Subject: RE: Planning Consultation on Y/29/20/DOC

APPLICATION NO: Y/29/20/DOC

Site Address: Garage Premises Main Road Yapton BN18 0EA

Description of Works: Approval of details reserved by condition imposed under ref Y/22/19/PL relating to Condition Nos 3 - materials & finishes for external walls, roofs and rooflights, 4 - surface water drainage, 5 - covered & secure cycle parking and 11 - energy efficiency

DETAIL OF RODDING EYE
(Scale 1:25)

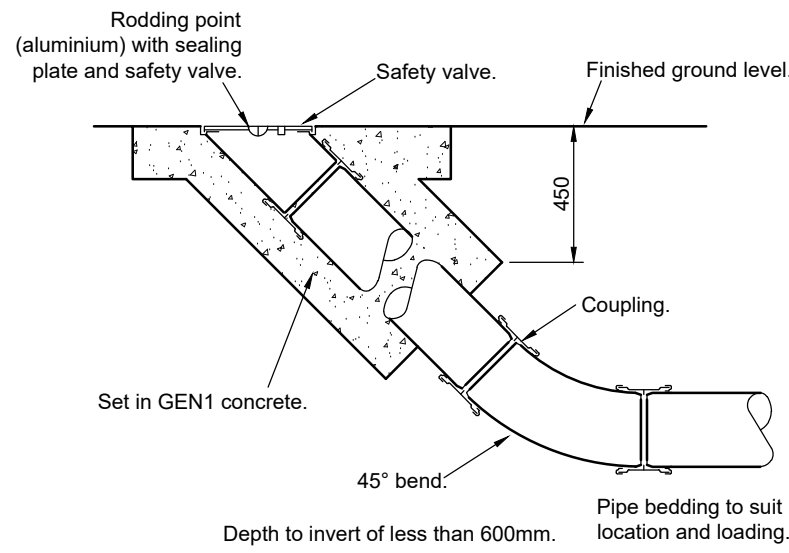
6. Add rodding eye's to legend and add invert levels.
7. All pipework not connecting to manholes to connect via oblique 45 degree junctions. Add note.
8. Permeable paving membrane to fully wrap the sub base ie extend under the base course.

PERMEABLE BLOCK PAVING CAR PARK DETAIL
(Scale 1:20)

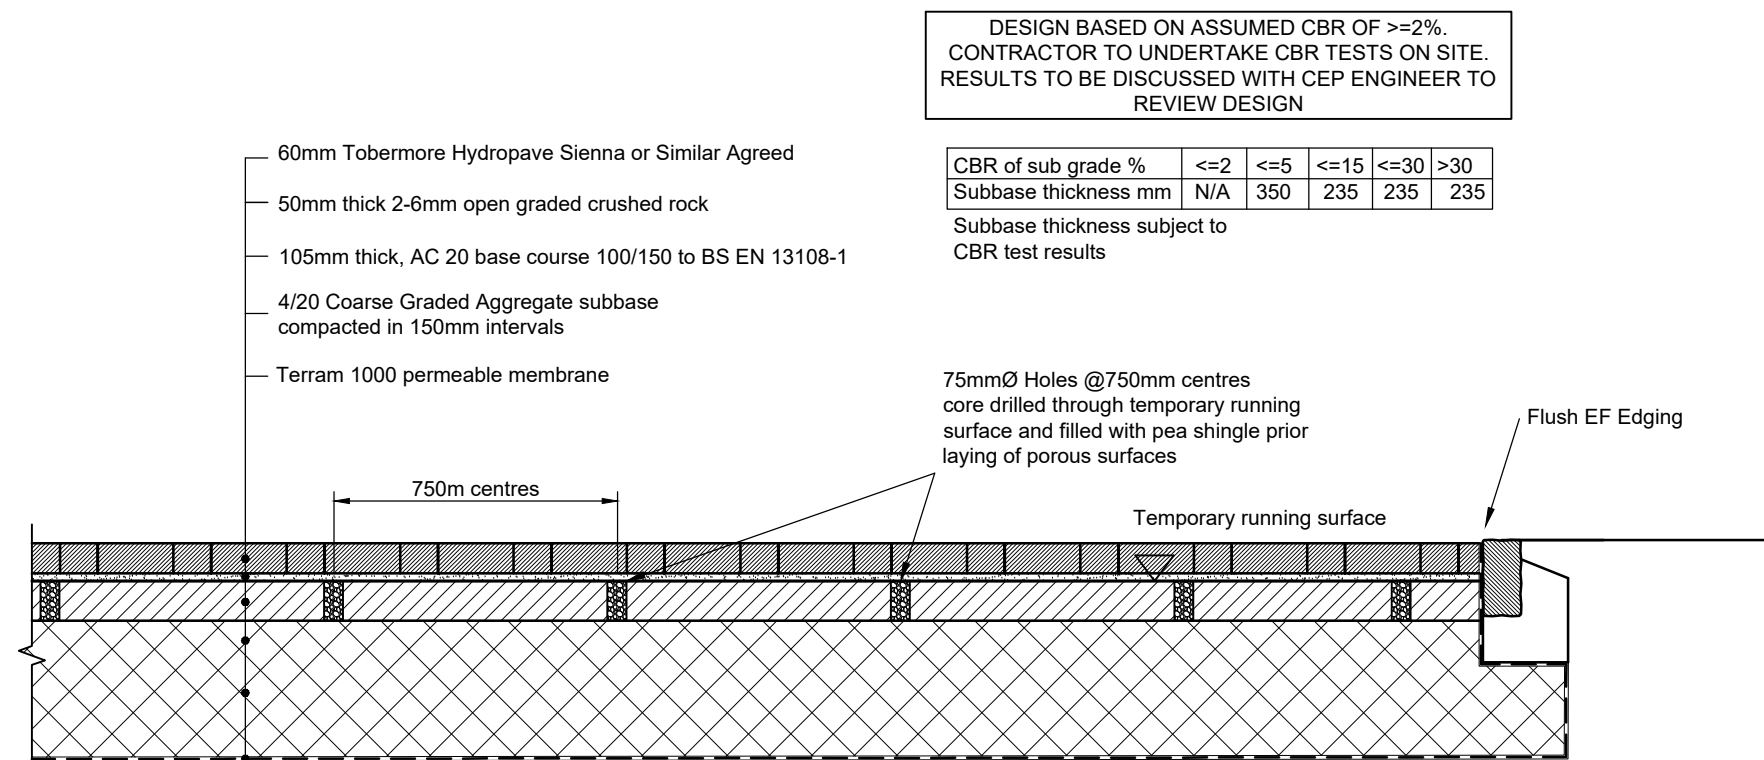
9. Specify min. sub base thickness based upon the drainage design and an assumed CBR. I appreciate further CBR testing may alter this.
10. Specify base level/s and finished surface level/s of the permeable paving. Any slopes will need to be accounted for, to ensure no detriment to the design.

CLIENT		Mr Pete Mountford	
PROJECT		Repture Yapton West Sussex	
TITLE		Proposed Layout Drainage Strategy Plan	
DRAWN	DATE	PROJECT NO.	
M Pacifico	Nov 2019	2326	
ENGINEER	CHECKED	DWG NO.	REV.
M Kempshall	SRM	101	B
SCALE	1:200 @ A3

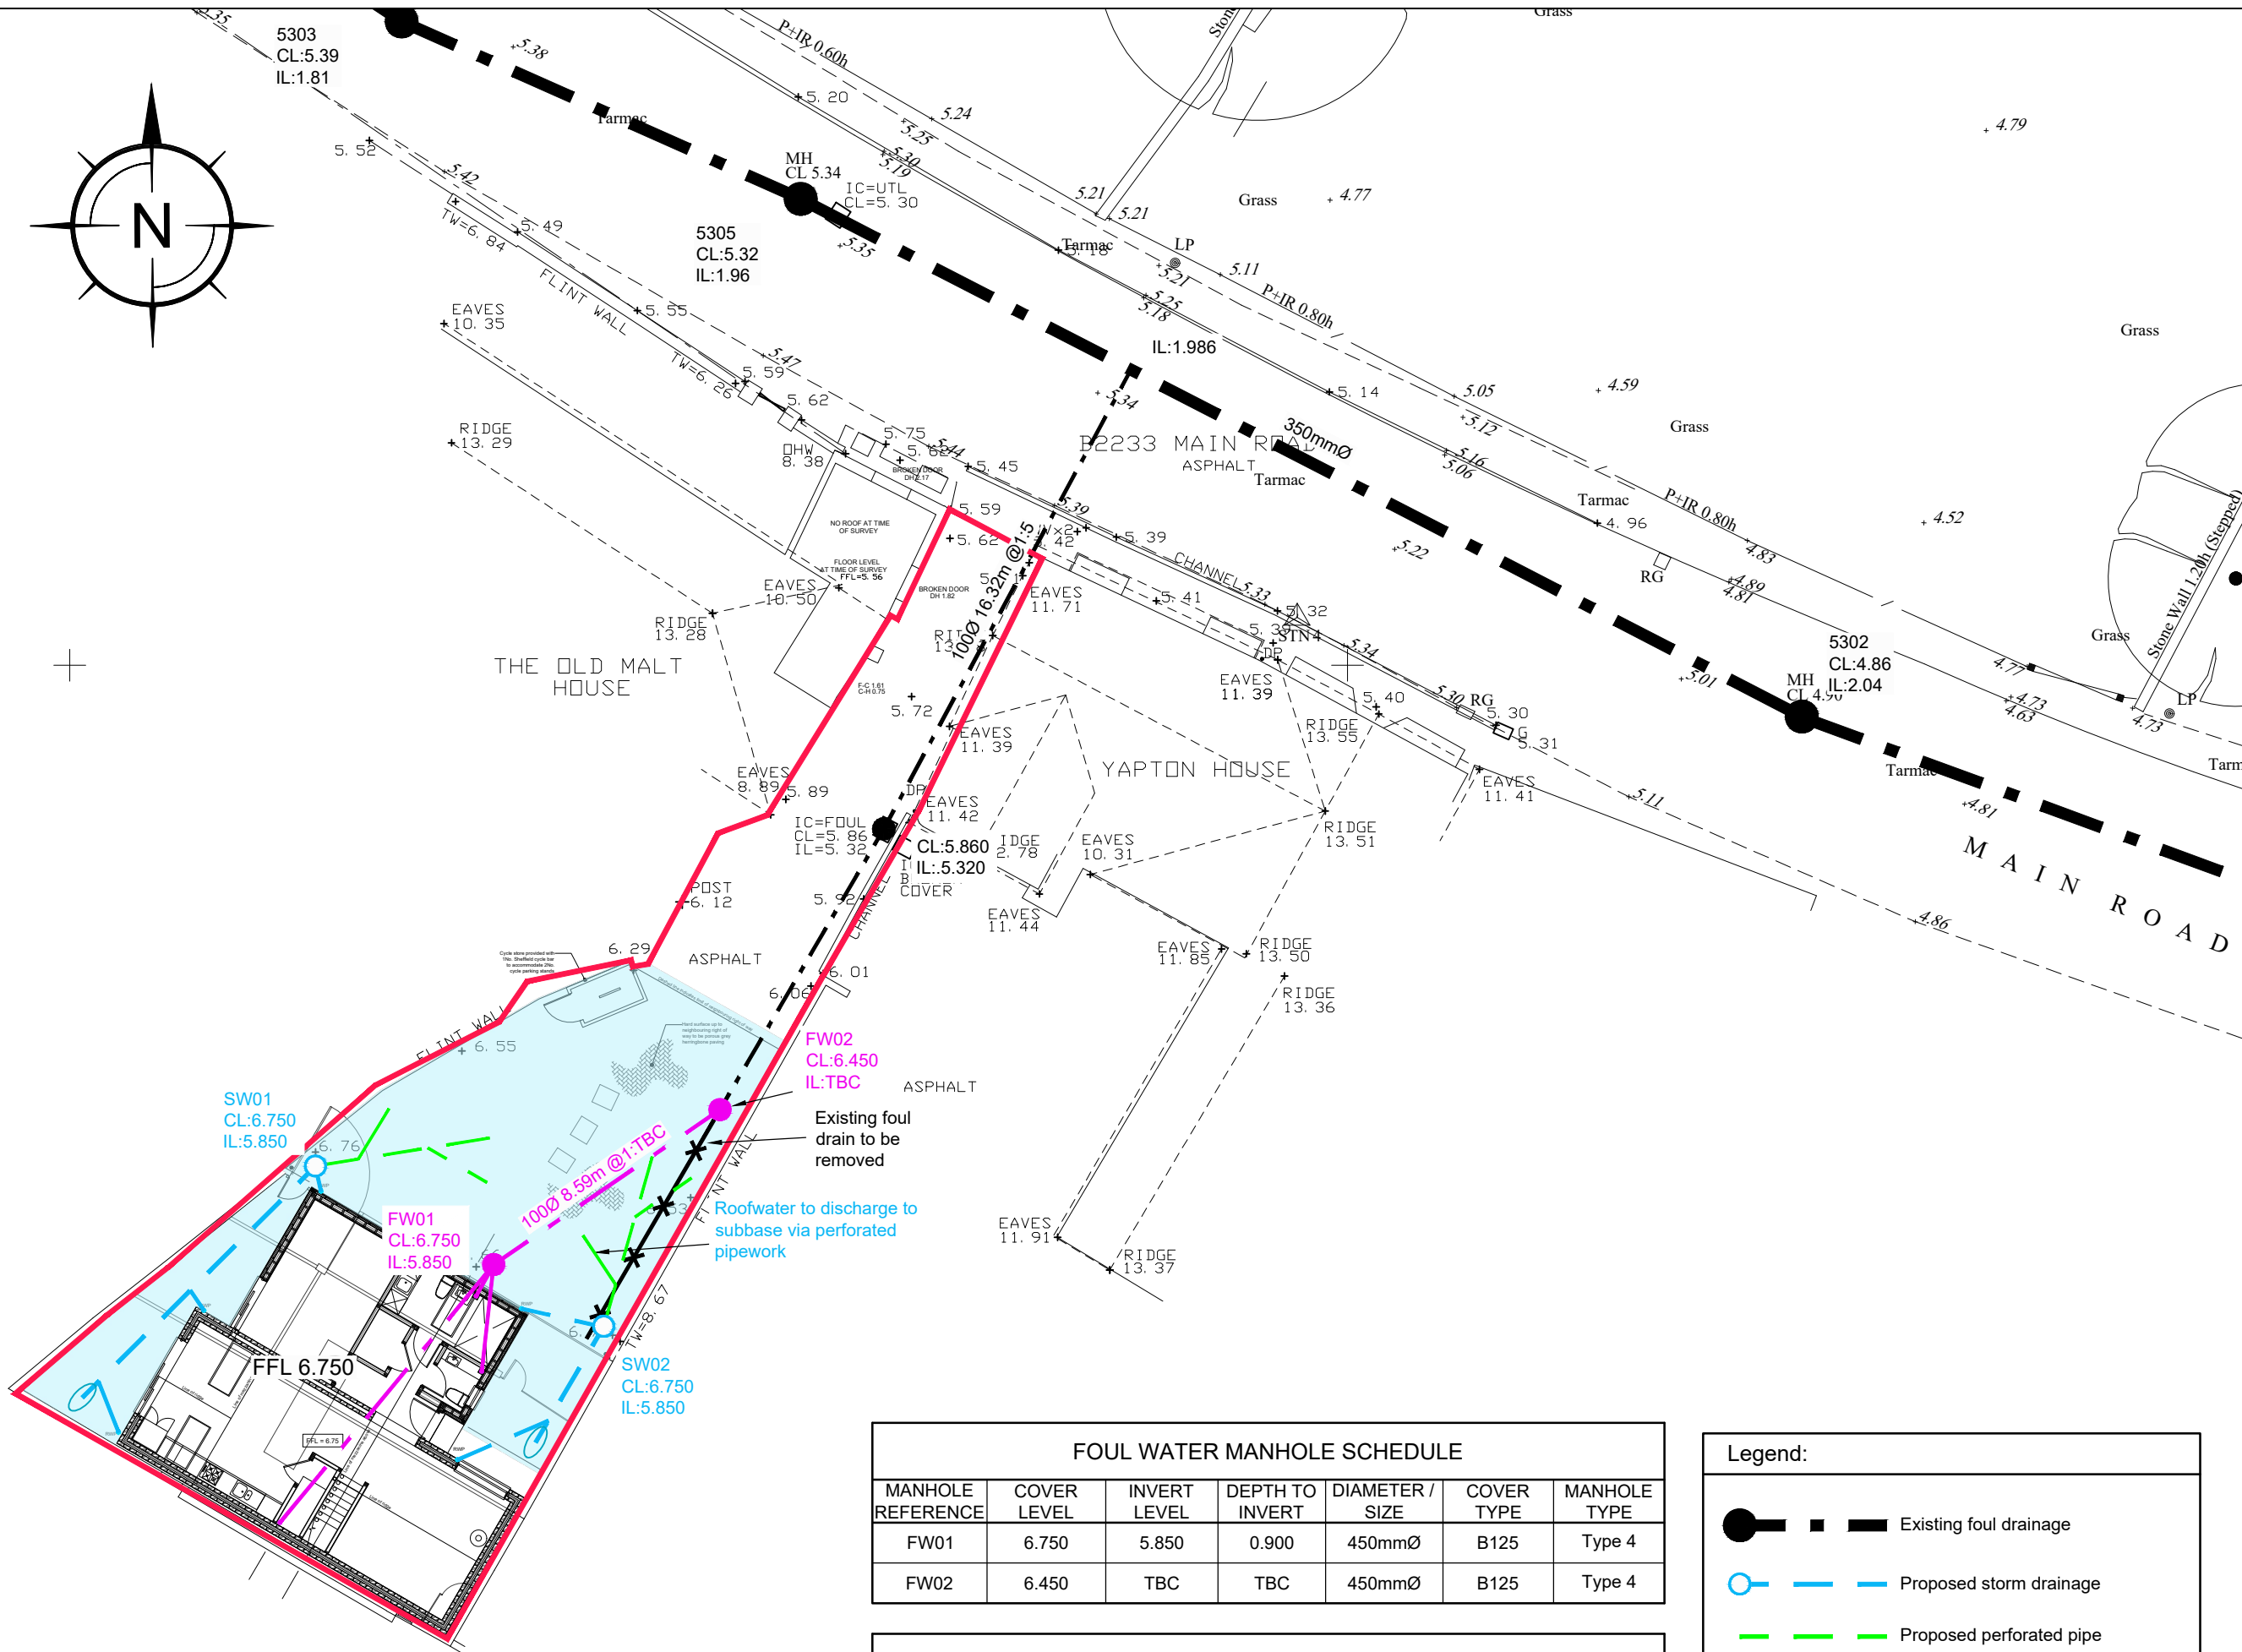
2. The impermeable road area at the northern end of the site. How is this to be drained? No run off is permitted onto 'Main Road', irrespective of what happens on site at present. Please provide a drainage solution for this area.

3. All roof water to discharge to the permeable pavement via diffuser units (to be 5m from buildings) rather than perforated pipework. Alter layout and provide construction details.

4. Silt traps to be provided upstream of each connection to the permeable paving. Also, provide construction detail.
5. Specify gradients/diameters of all pipework.
